Our Ref: TR010032

Date: 28 November 2022

Application by National Highways for an Order Granting Development Consent for the Lower Thames Crossing

Advice following issue of decision to accept the application for examination

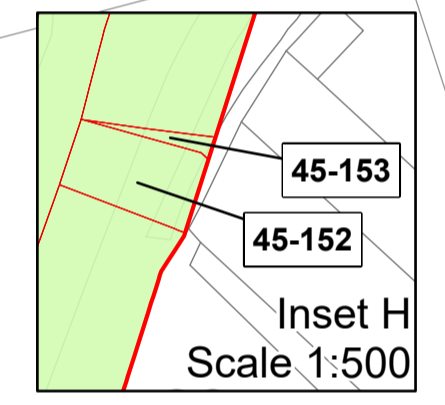
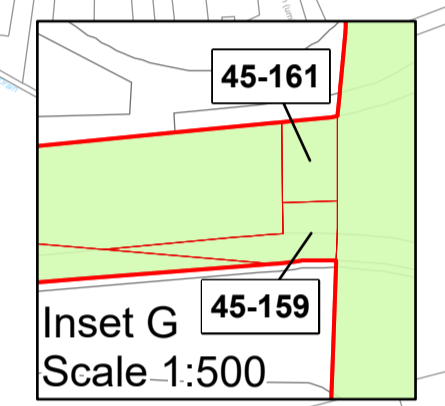
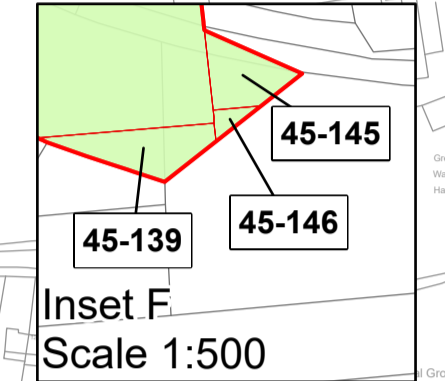
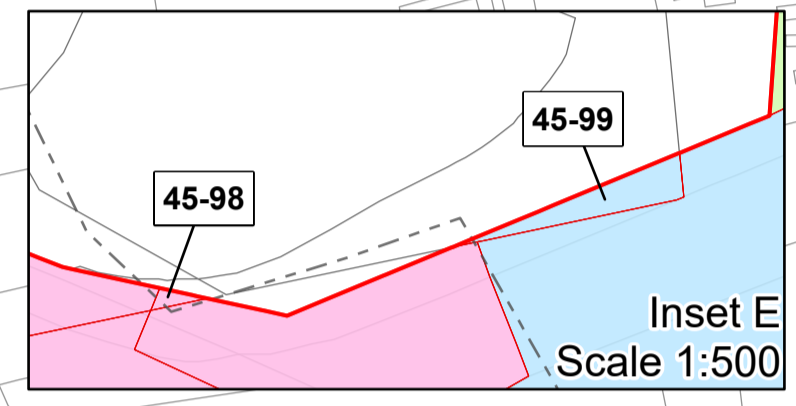
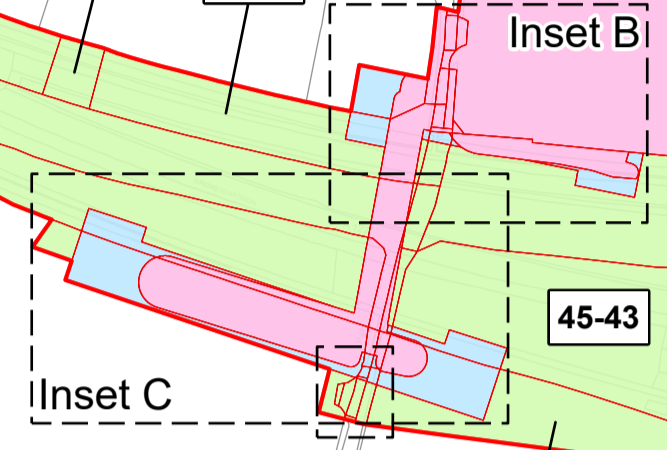
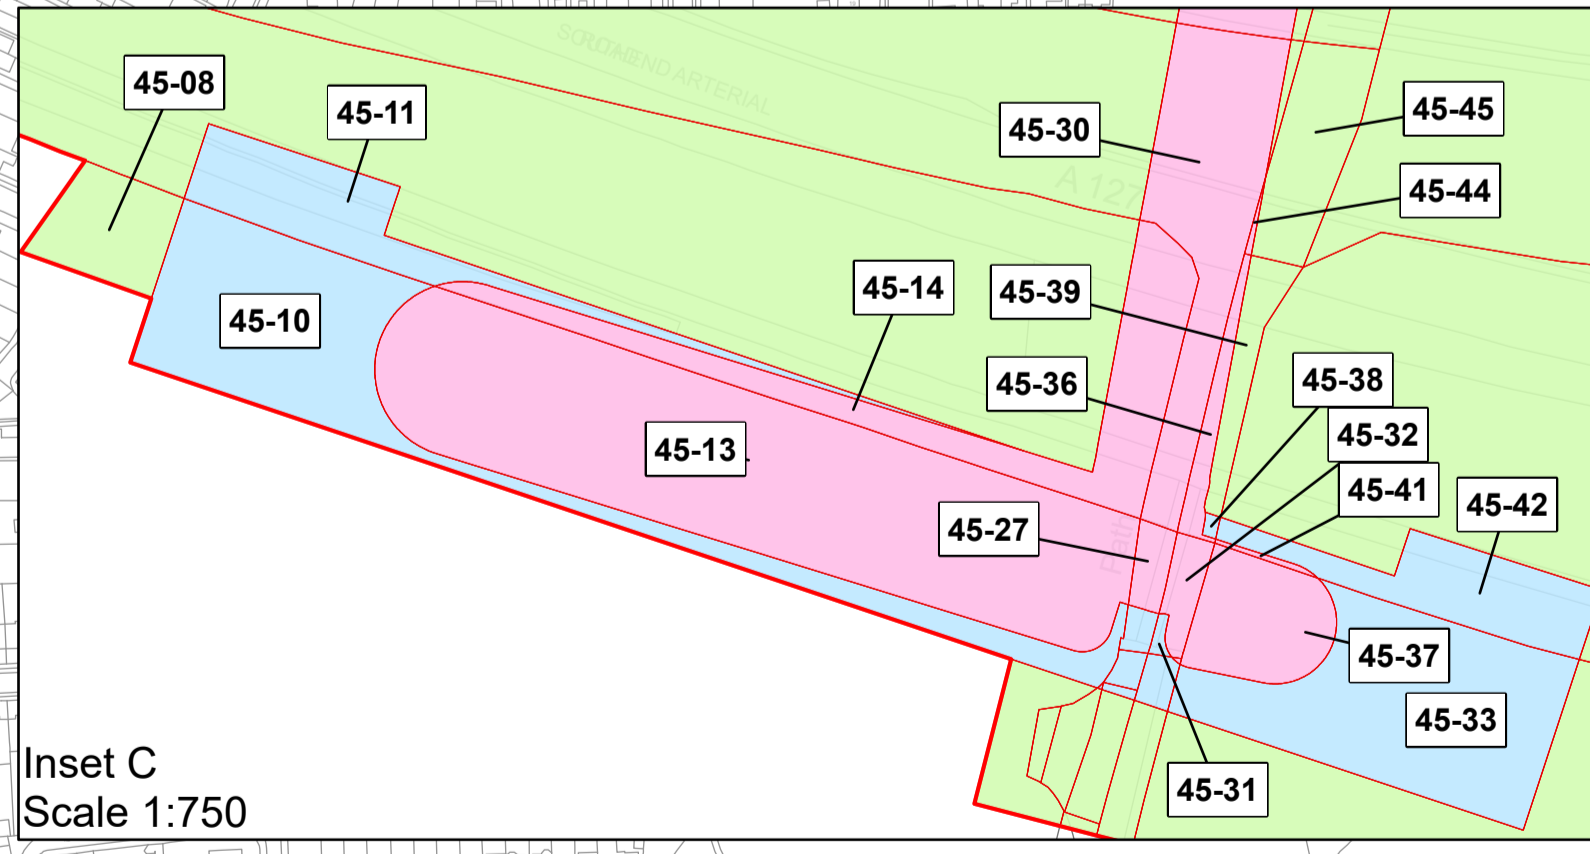
- The plot numbers on Volume C (sheets 21-49) of 2.2 Land Plans are not searchable.
- The Applicant is advised to undertake a full check of the Plans and make corrections of errors or for clarification, for example:

- Ensure all cut lines are included and unobscured, eg, cut line to sheet 10 on sheet 4 on 2.2 Land Plans and between sheets 23 and 25 on all Land Plans.

- Ensure that all descriptions in the BoR are accurate according to the Land Plans and descriptions of similarly located plots, eg, 04-17 and 04-12.
 - Ensure all plots are given a unique identifier where necessary, eg, 04-30, 04-37, 04-242.

- Ensure all plots are clearly numbered, eg, the small plot to the North of 04-185, the small plot to the South of 04-256 and the small plot to the South-East of 08-13 on the Land Plans.

- Ensure that all plots included in the BoR are identified on the Crown Land Plans, eg, 04-272 and 04-273.
 - Ensure that all plot labels and boundaries are legible and unobscured.
